**269 Commercial St. BP# 2016-02613**

Jeanie Bourke  
Code Enforcement Officer/Plan Reviewer

ARCHITECTURAL
DRAWING
BY
DATE

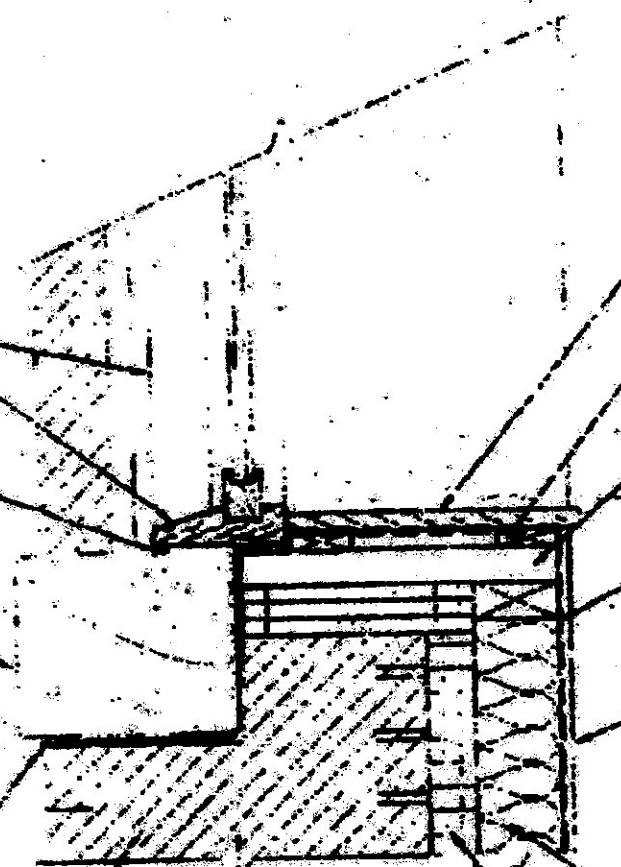
1. I do not see any specifications on the windows in the submitted documents including dimensions, and insulating factors. The scope states that 3 of the windows will have newly constructed RO in the existing MO, are you just replacing damaged material?

**\*\*Please see attached file for window details. I am replacing six windows. The ROs are being rebuilt as per engineered drawings attached to the original permit submission.\*\***
